EPC STORMWATER REVIEW COMMENTS
IN ORANGE BOXES WITH BLACK TEXT

CANYON CREEK DEVELOPMENT

GRADING AND EROSION CONTROL PLANS

OCTOBER 2024

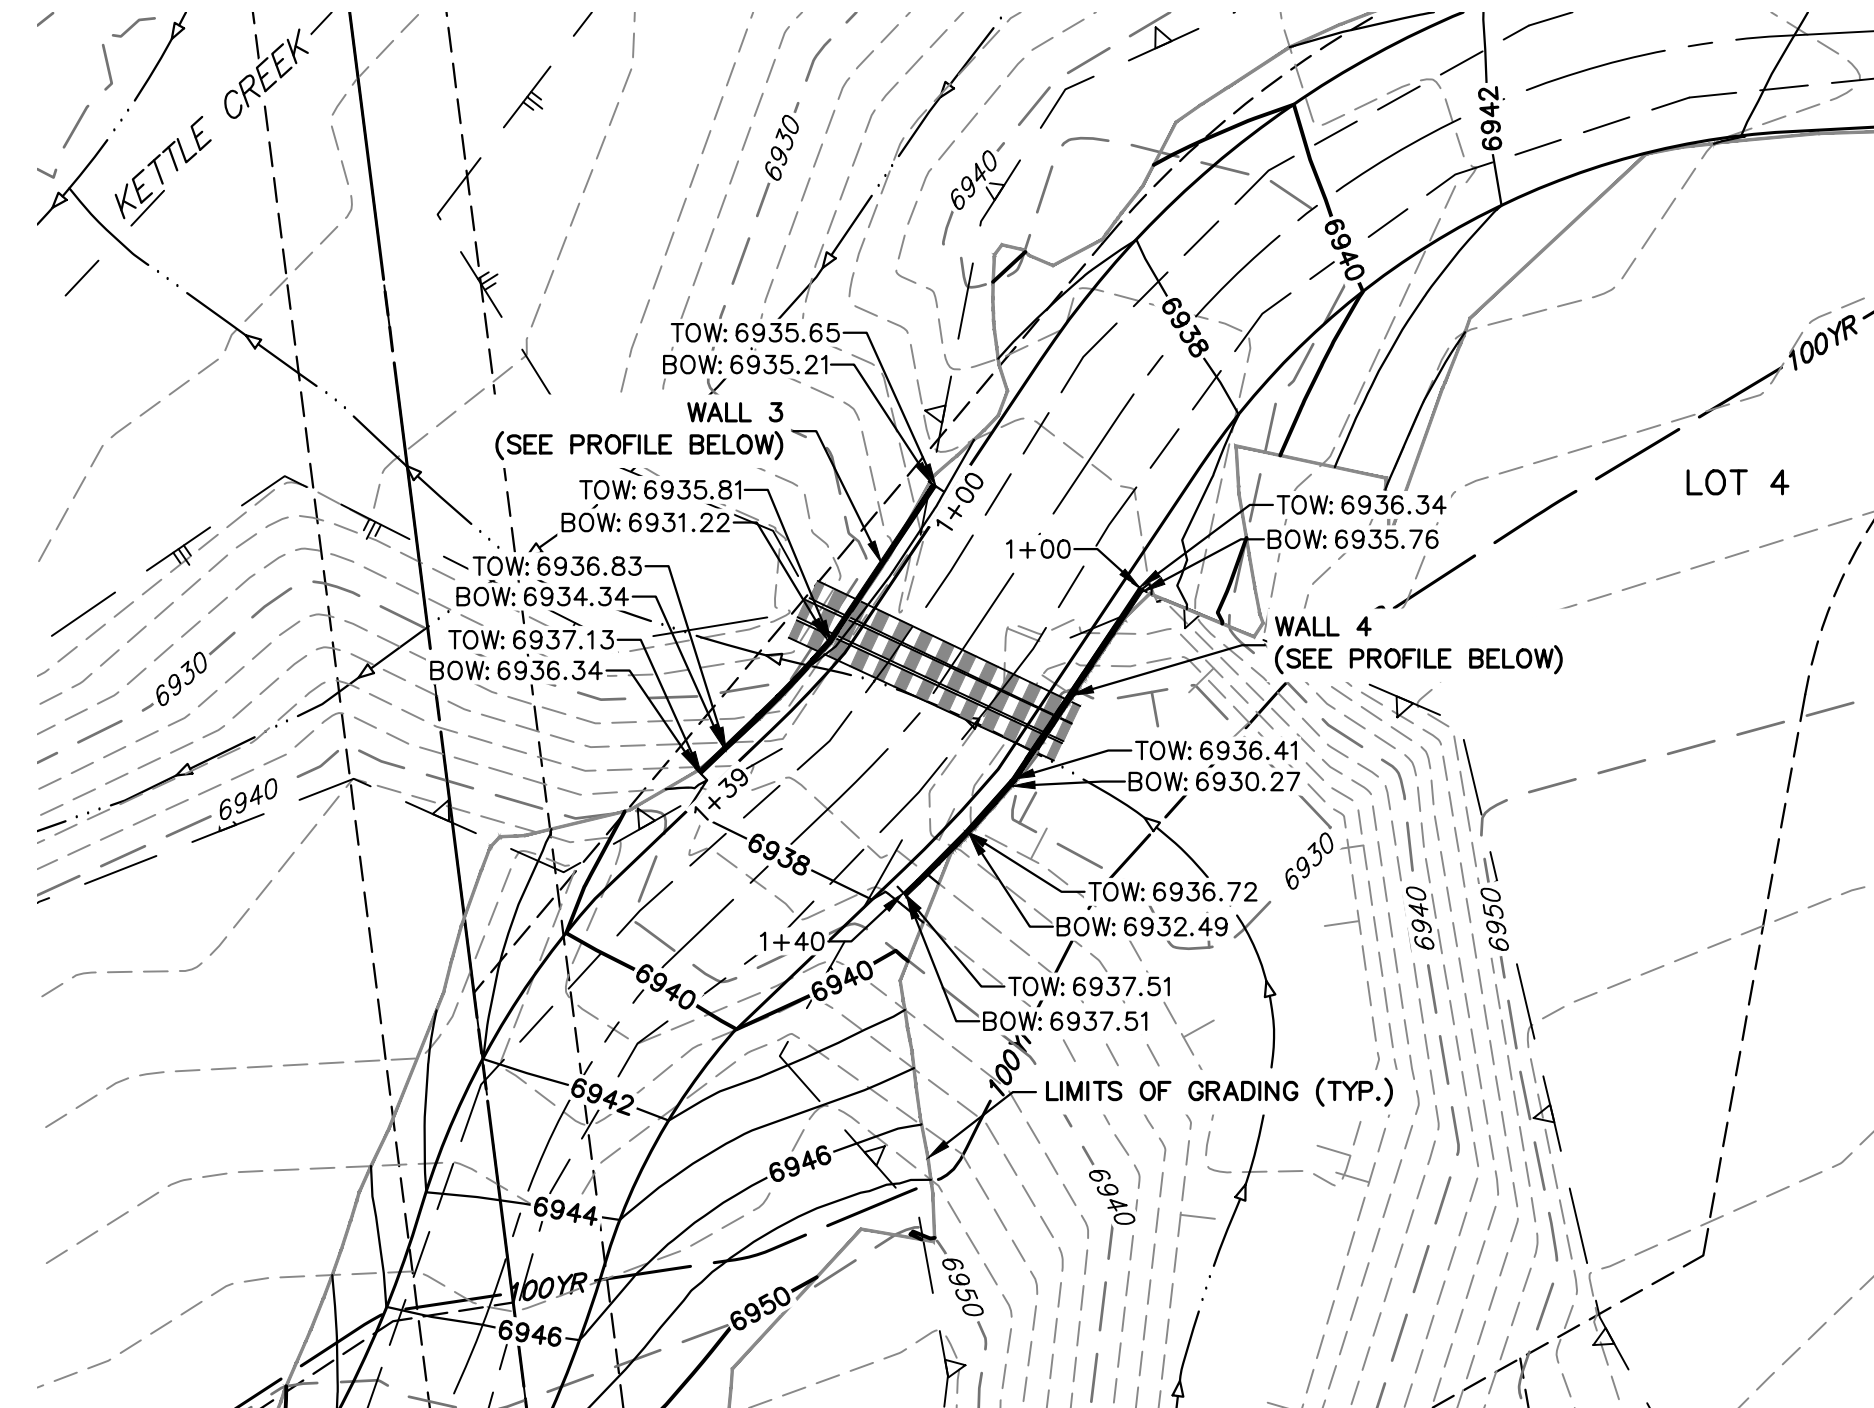
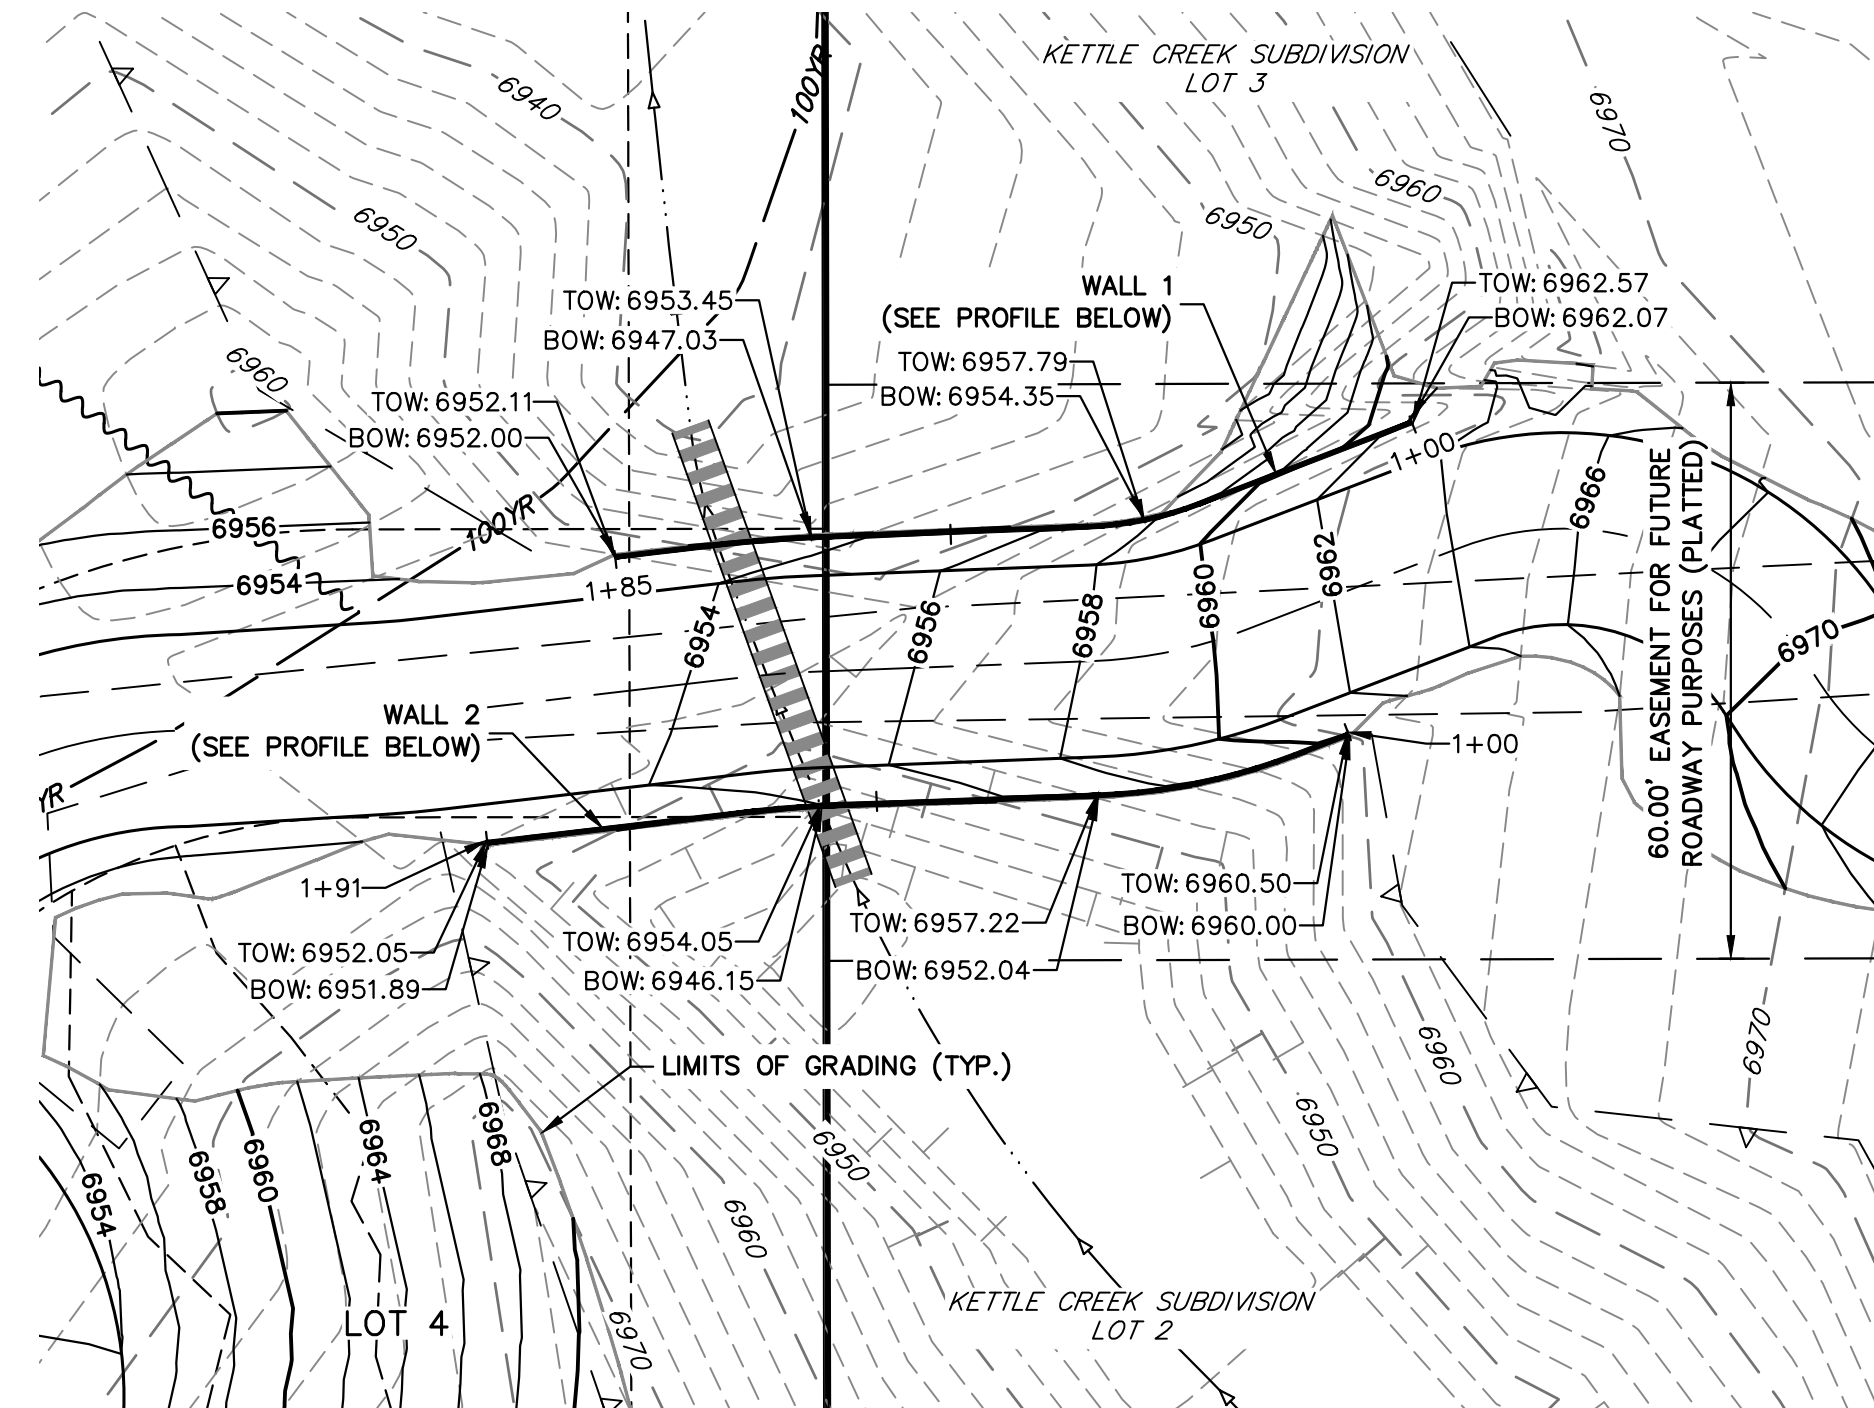
GEC Checklist Item j - Show limits of FEMA floodplain
 GEC Checklist Item m - show limits of disturbance. If "limits of disturbance" and "construction boundary" are the same, change to "limits of construction/disturbance" or otherwise show as separate line types for each on the legend and figure.
 GEC Checklist Item p - Identify areas of cut/fill

See comments on construction drawings regarding driveway grade exceeding the allowable 12%. Reference LDC 6.3.3.C for more information on what is allowed. Revise.
